**Consultation Response from KC,
Highways Development Management**

2026/90441 Huddersfield Bus Station, Upperhead Row, Huddersfield, HD1 2JN

Discharge of details reserved by conditions 11 (bins), 15 (BEMP), 22 (Phase II Intrusive Site Investigation Report) on previous permission 2025/91604 for variation condition 2 (plans) on previous permission 2024/92302 for refurbishment comprising (phase 1): facade improvements including Henry Street entrance; replacement shop fronts; alterations to external bus apron; extension and alterations to existing barrier within the bus alighting lane adjacent to Henry Street; (phase 2): new entrance canopy; public realm improvements; cycle hub; facade improvements including replacement shop fronts

Date Responded: 14/07/2026

P1 Site Plan Bin Store Location  
Scale: 1 : 100

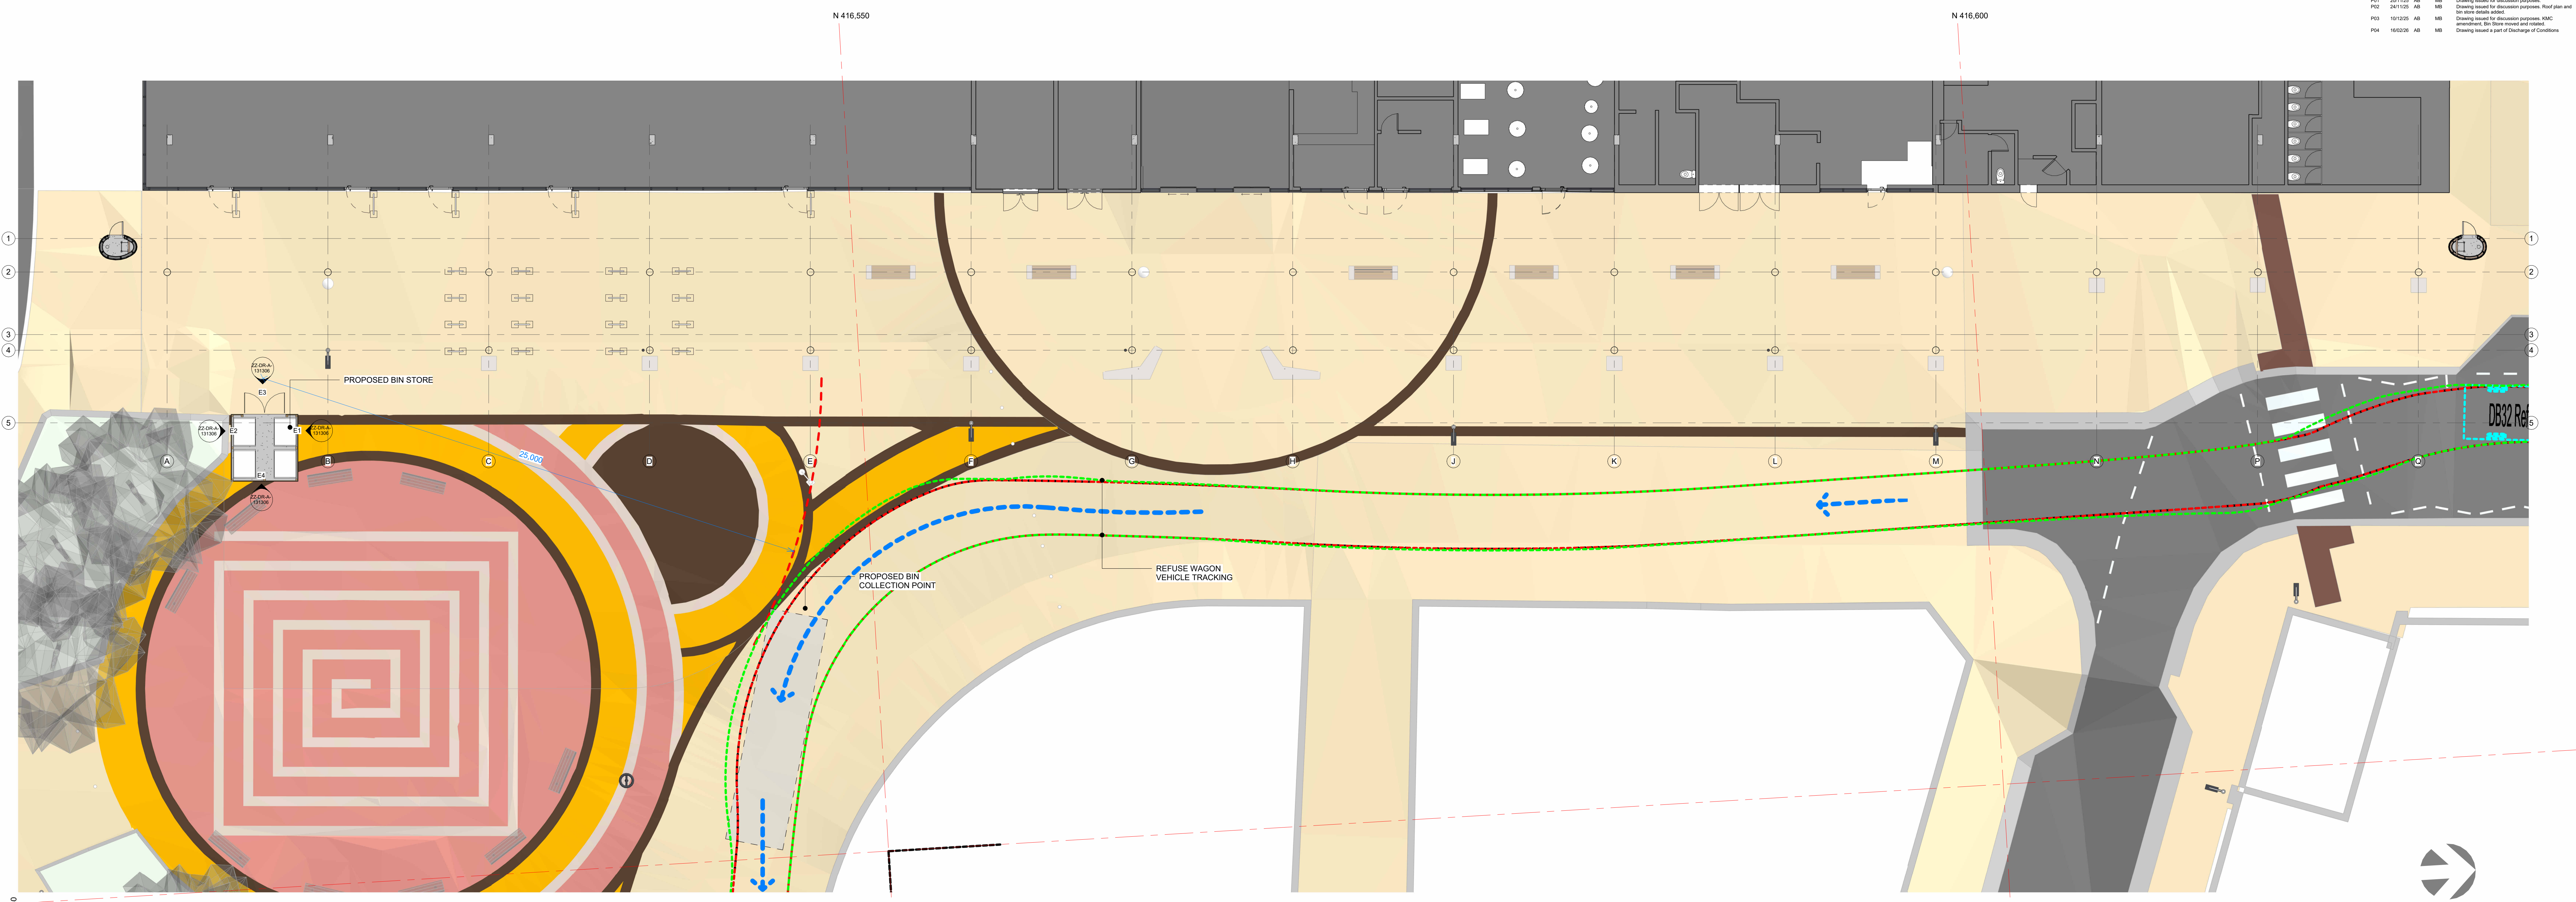
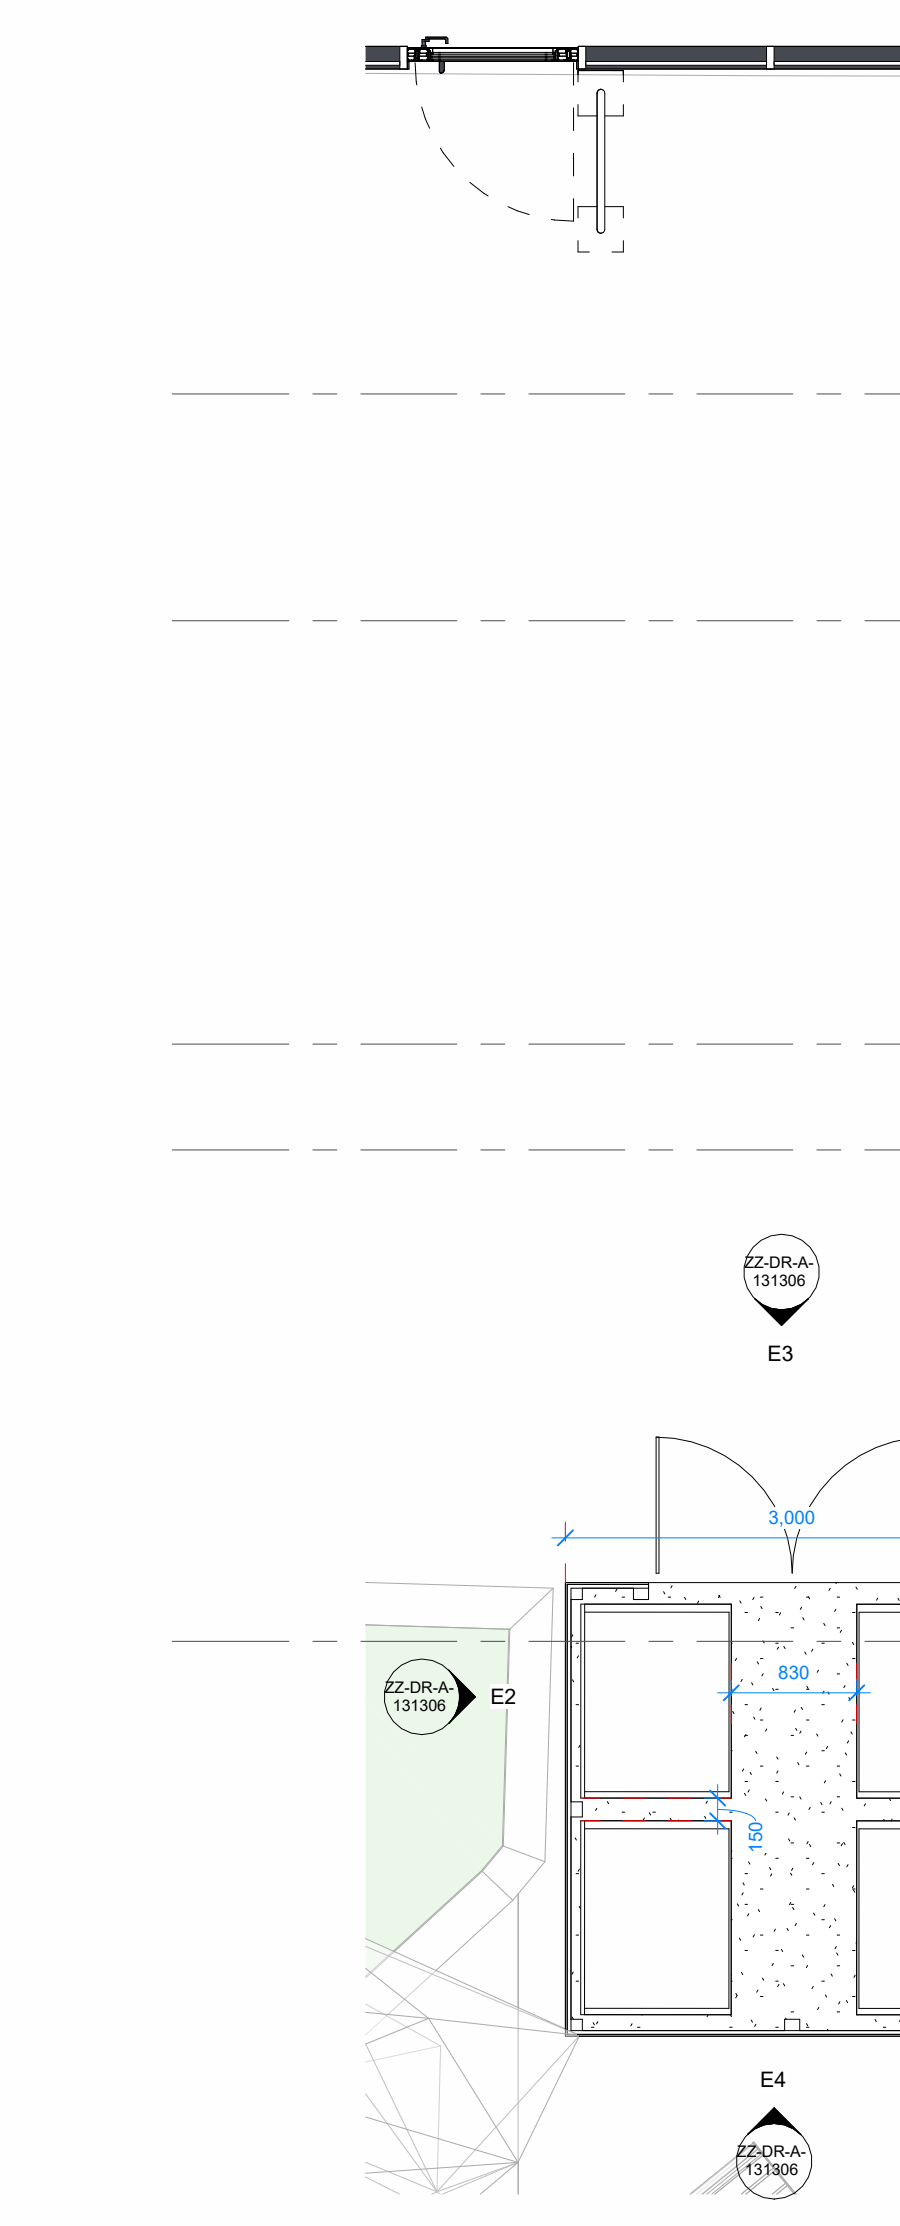
Part of the proposals are to formalise the existing bin storage located on the bus station forecourt on Upperhead Row with a wooden bin store that would remove the bins from open display in a prominent position on the pedestrianised area outside the bus station to enhance the street scene and bus station refurbishment.

It is noted that the location of the proposed bin store is within the adopted highway and is not included within the proposed stopping up zone underneath the new canopy. It is the Local Highway Authority's policy that formal bin storage should not take place within the adopted highway and because of this we would have submitted an objection to the proposals and requested that the condition should not be discharged.

We would not wish to see a precedent set that will allow other developments within town centre locations to propose waste stores on the adopted highway in contravention to existing LHA policy. However, given the information presented above, for this specific instance only, we would, on balance, not wish to object to the discharge of condition 11 of 25/91604.
